ASSESSMENT REPORT

18 Honeysuckle Drive, Newcastle SSD 6580 MOD 1

Drawing
PARKING LEVEL 2 PLAN

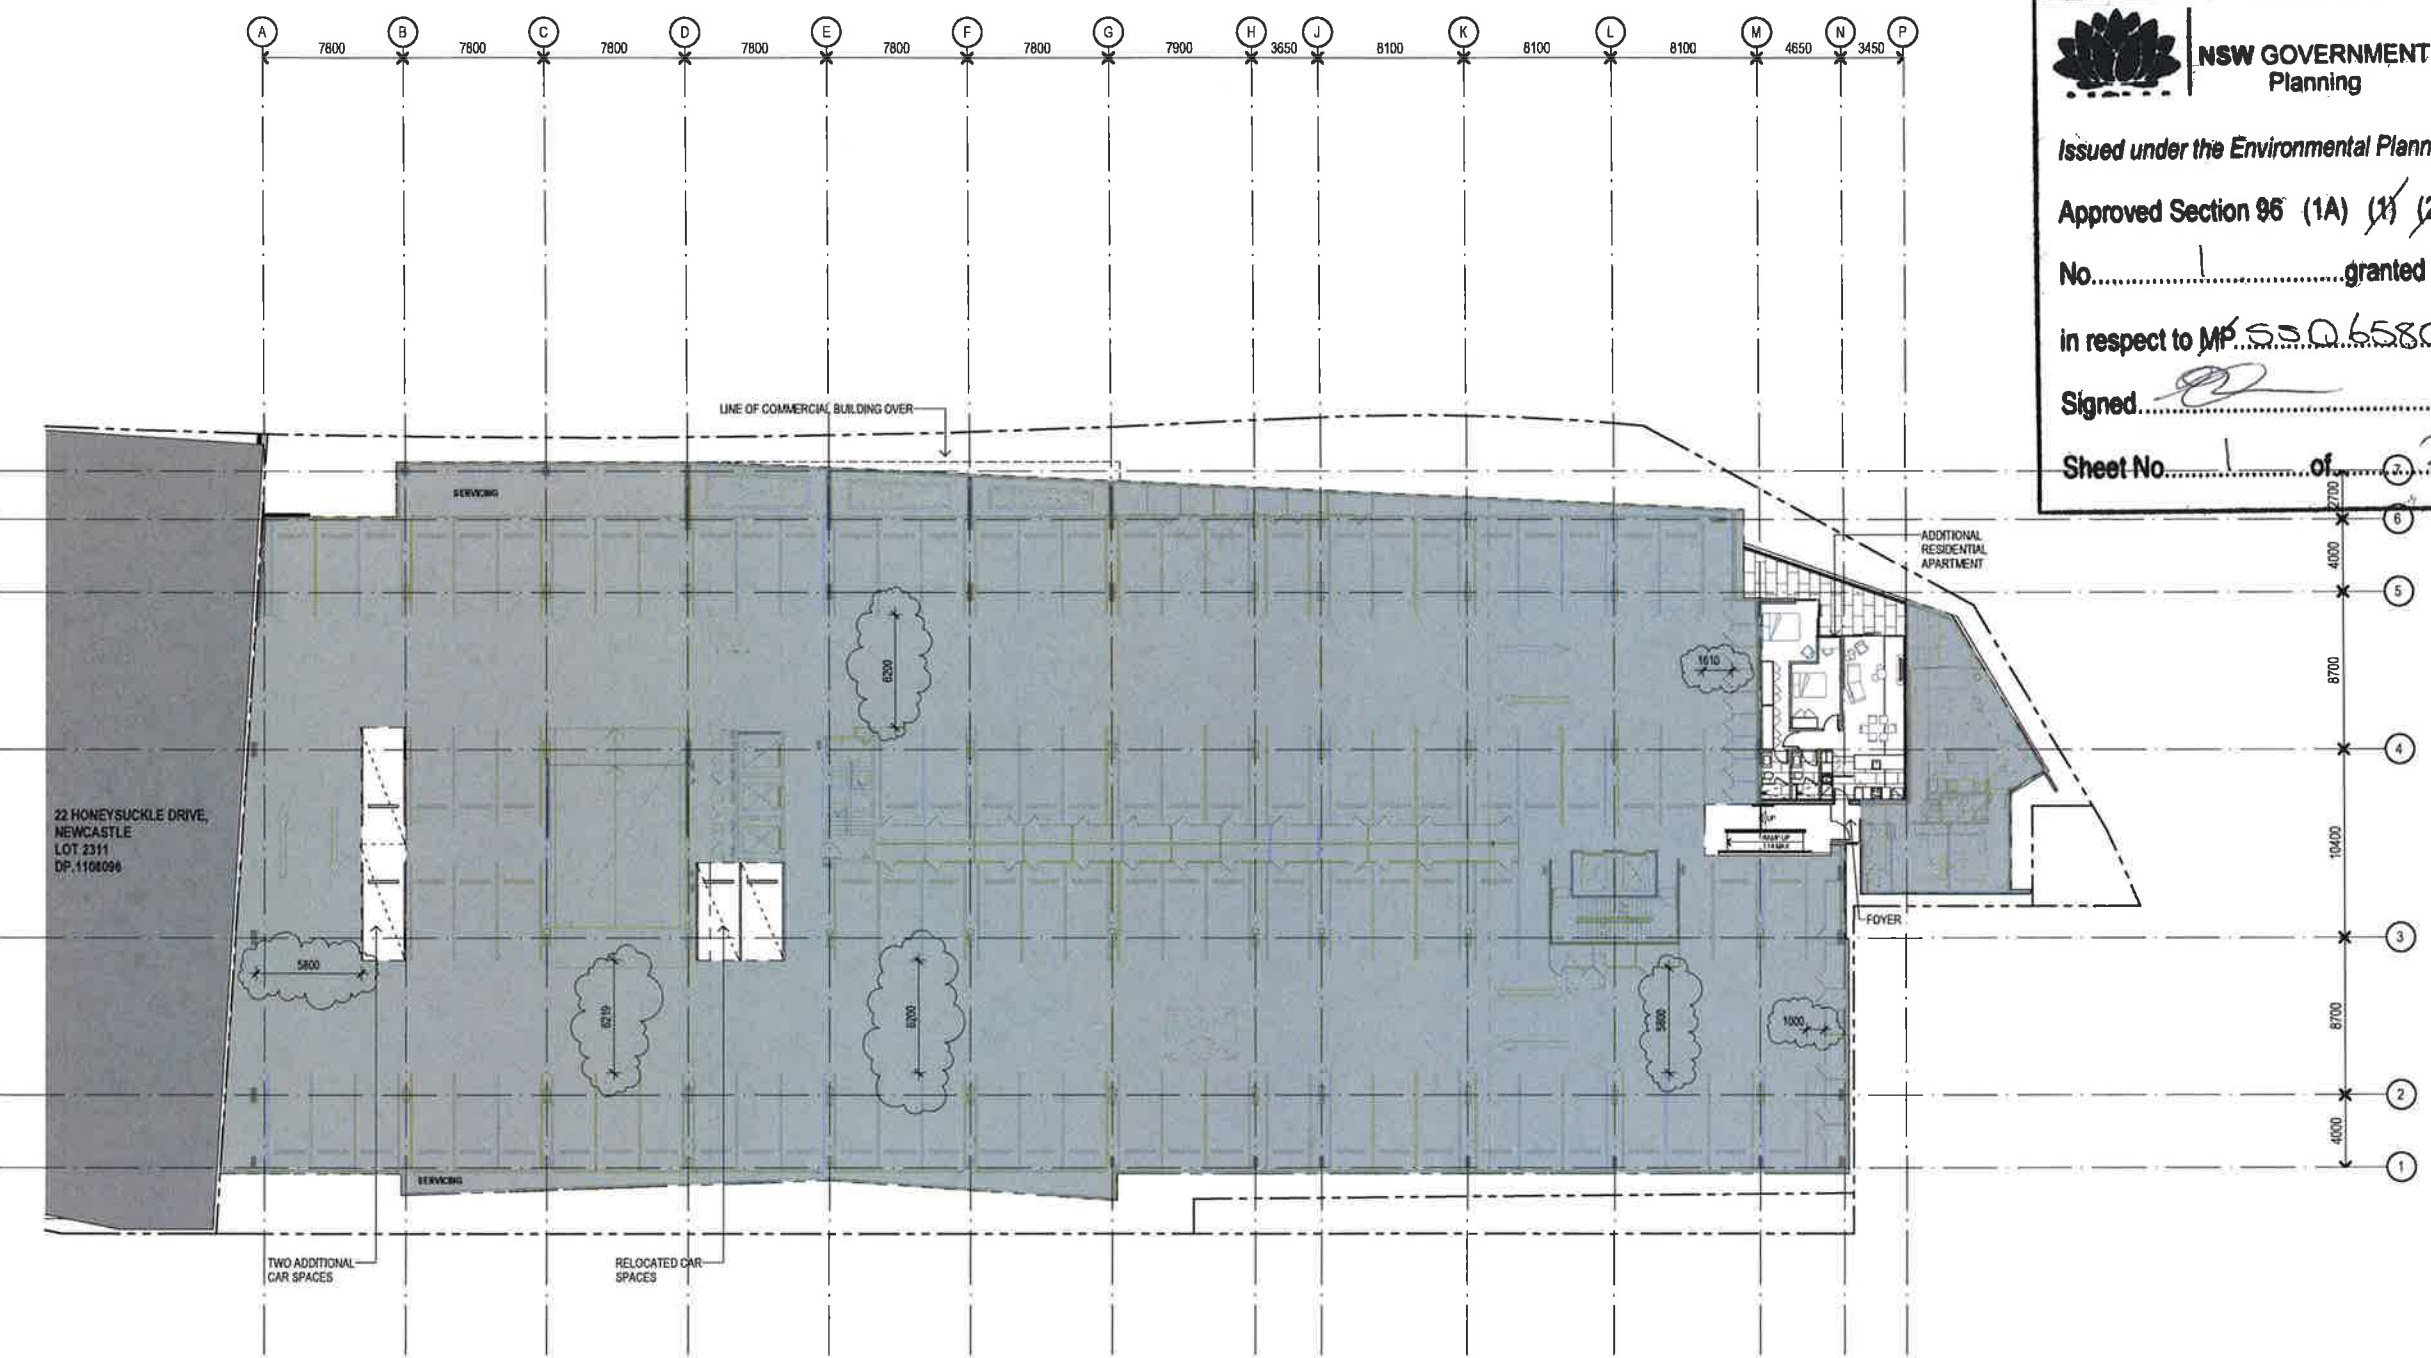
On 4 January 2016 the Proponent lodged an application (SSD 6580 MOD 1) seeking to amend approved plans to include an additional two bedroom unit, accessible from the carpark on level two, and to make some minor changes to the carpark layout.

The modification is requested on the basis that the inclusion of an additional apartment on parking level two will provide better integration with the façade and improved surveillance of the street frontage along Honeysuckle Drive.

Car Parking Provision and Layout	<ul style="list-style-type: none"> The proposed modification seeks to increase car parking from 193 to 195 spaces. The Department is satisfied that the additional car parking spaces would adequately service the new two bedroom apartment. The Newcastle City Council submission outlined that plans for the proposed modification did not demonstrate compliance with Australian Standard 2890.1-“Parking Facilities” in terms of aisle widths and parking space dimensions. In response, the Proponent outlined that the aisle width of the car park on Level 2 is designed to be equal to, or greater than the standard 5.8m requirement, and the width of the individual parking bays would be equal to or greater than the 2.4m minimum requirement. The Department is therefore satisfied that the carpark would comply with the Australian Standards. 	No additional conditions or amendments necessary.

Drawing:
BUILDING ELEVATIONS
Scale: As indicated @ A1 Date Performed: 19/12/2015 2:45:22 PM
Project Number: 202878 Drawing Number: DA401 Issue: 8

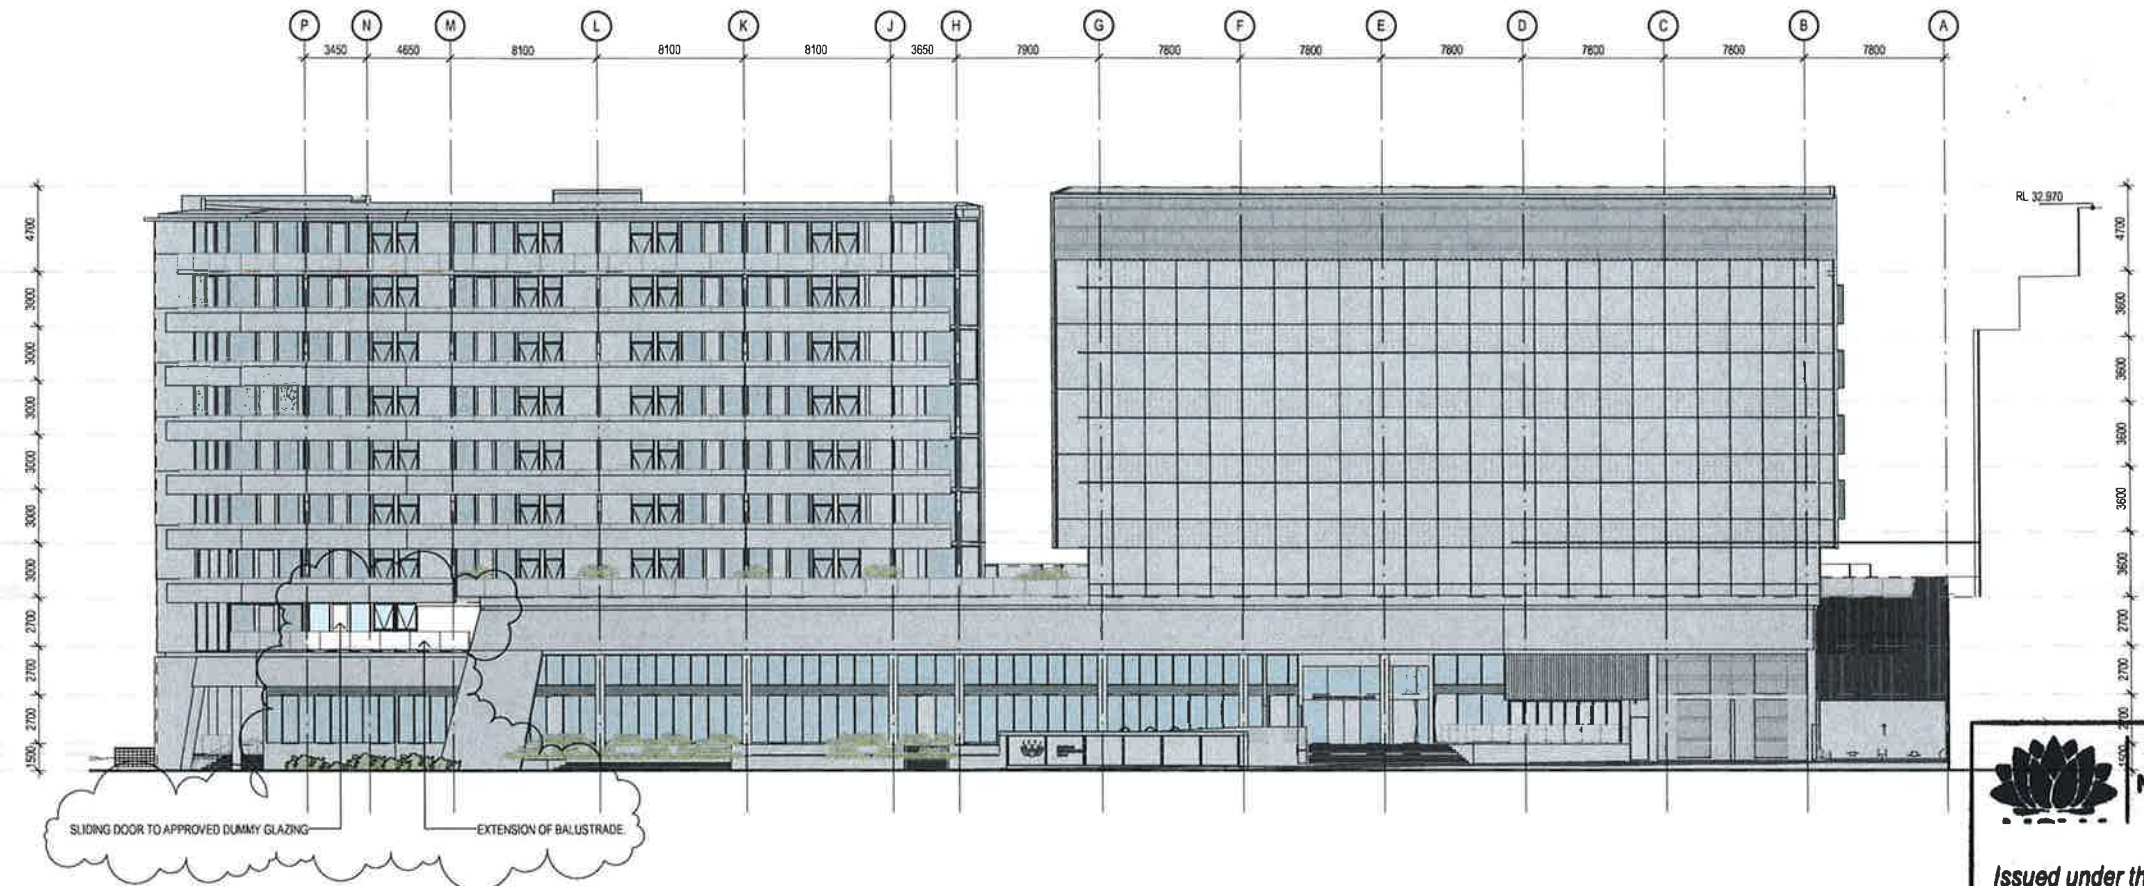
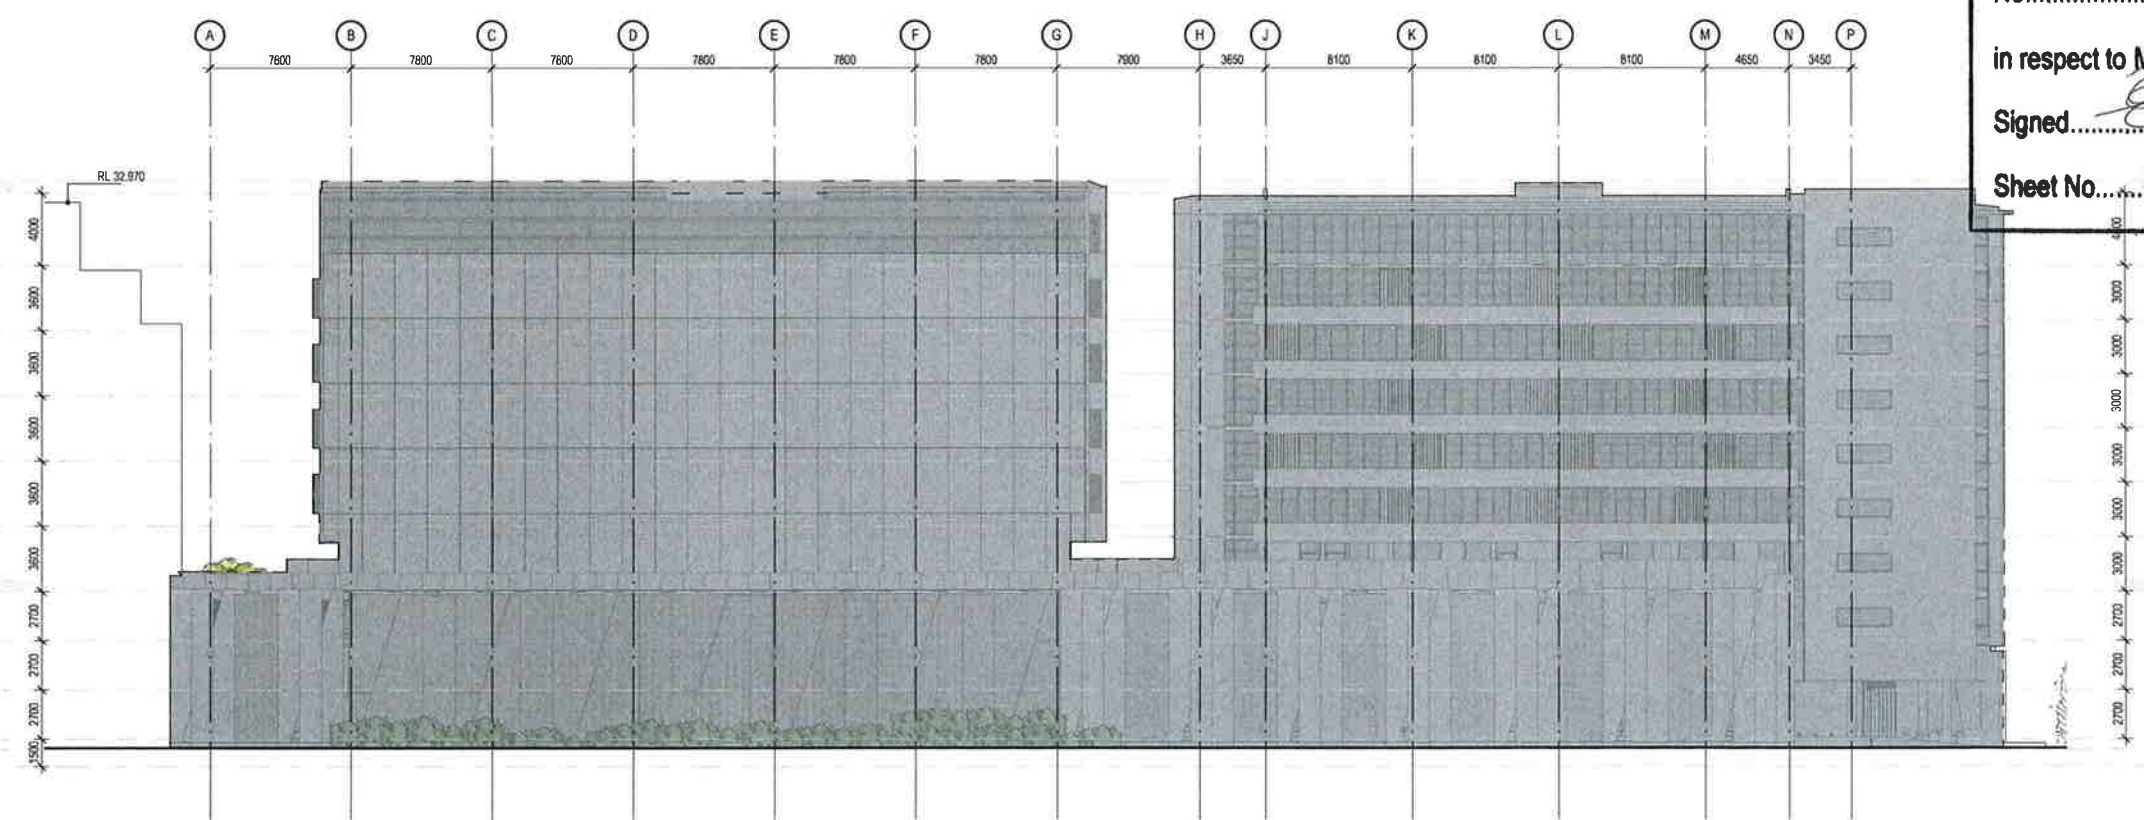
Issue	Consideration	Recommendation
<i>Built Form and Urban Design</i>	<ul style="list-style-type: none">• The proposal seeks approval to include an additional apartment within level 2 of the approved building. The proposed changes are predominantly internal and would not materially change the approved built form or the appearance of the building from the public domain.• The only perceptible external change to the building would be a small change to the balcony and balustrade alignment as shown in Figure 2 and Figure 3. This is considered to be a minor change which would improve the appearance of this part of the building.• The Department is therefore satisfied that the integrity of the overall building design will be retained.	No additional conditions or amendments necessary.
<i>Floor Space Ratio</i>	<ul style="list-style-type: none">• The additional apartment would increase the Gross Floor Area (GFA) of the development by 77sqm. This would increase the Floor Space Ratio (FSR) from 3:1 to 3:02:1.• Council raised concerns that the proposed development had not addressed clause 4.6(3) of the Newcastle Local Environmental Plan (LEP), 2012, relating to exceptions to development standards.• However, the Department has confirmed that the FSR applicable to	No additional conditions or amendments necessary.
